About the application

Application number: 2023/93539	
What is the application for?:	Outline application, including the considerations of access appearance, layout,
Address of the site or building:	Land adj, Ledgard Bridge Mill, Back Station Road, Mirfield, WF14 8NZ
Postcode:

River Elevation 1: 200

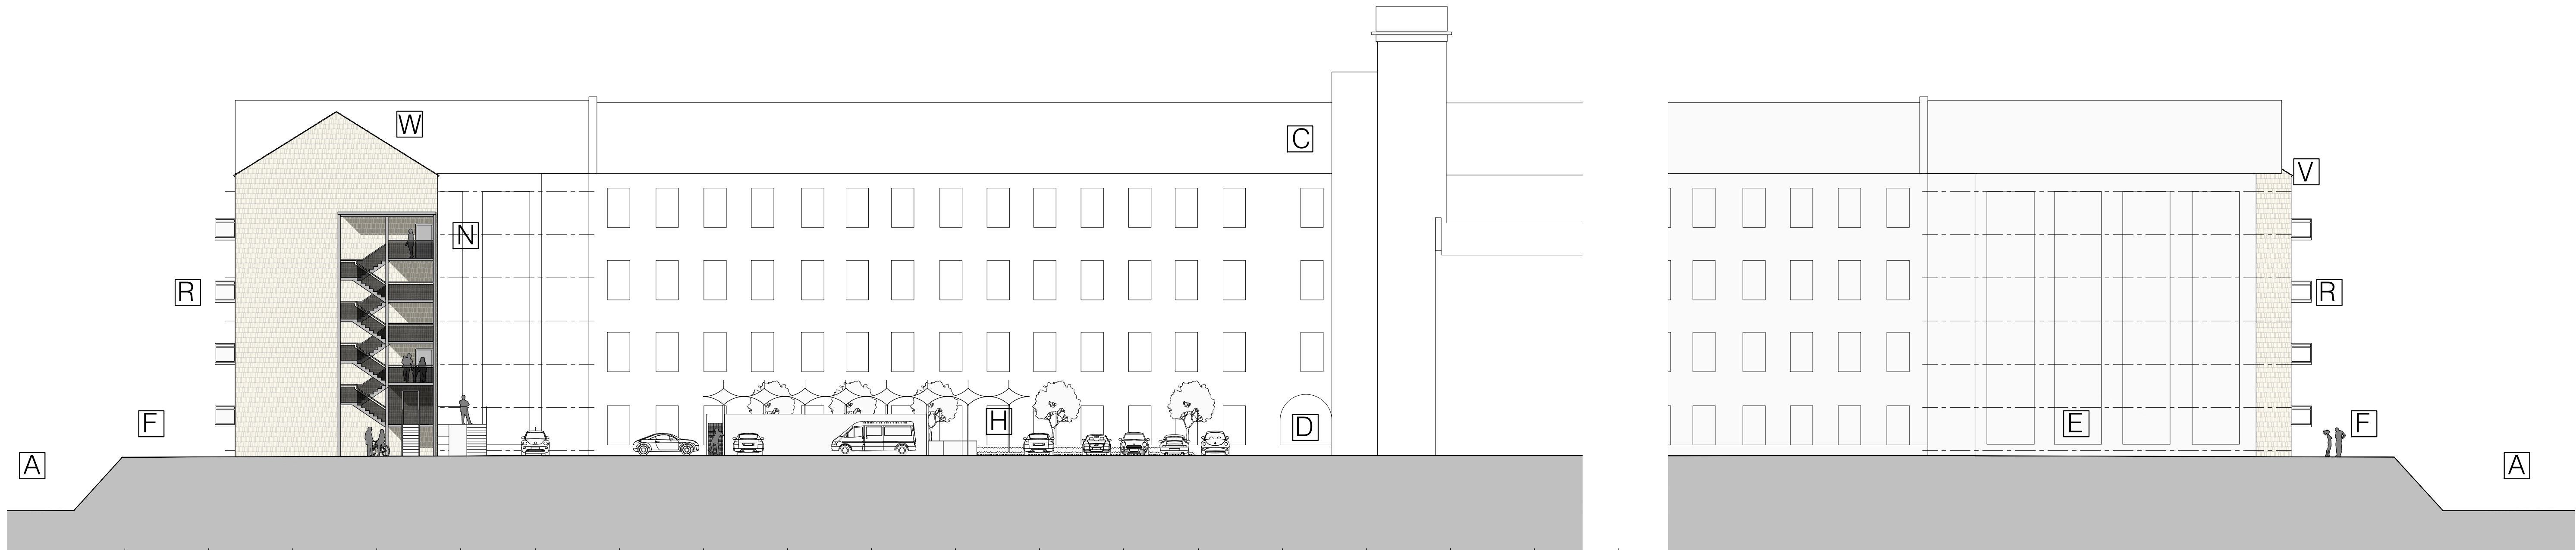
Type of comment: An objection	
Do you wish your comments to be published on the website anonymously?	<input type="checkbox"/> Yes
<p>As an owner of an apartment at Ledgard Bridge which faces the land which is identified I would object to the excessive height of the proposed development. Whilst I fully support the use of Brown Field land as opposed to Green Field, also the additional much needed affordable homes, I believe that 6 stories is too high to be sympathetic to the original mill conversion of Phase 1. Other apartment developments in close vicinity are no higher than 2 or 3 stories. Whilst I am aware that we are not entitled to a pleasant view, I think the impact of a 6 story block will be detrimental to residents of Ledgard Bridge. I am also pleased that flooding is being mitigated, however this may place the ground floor residents of Ledgard Bridge at greater risk with the loss of natural water storage from river overflow. The residents have only just recovered from flooding from Storm Ciara. Thank you.</p>
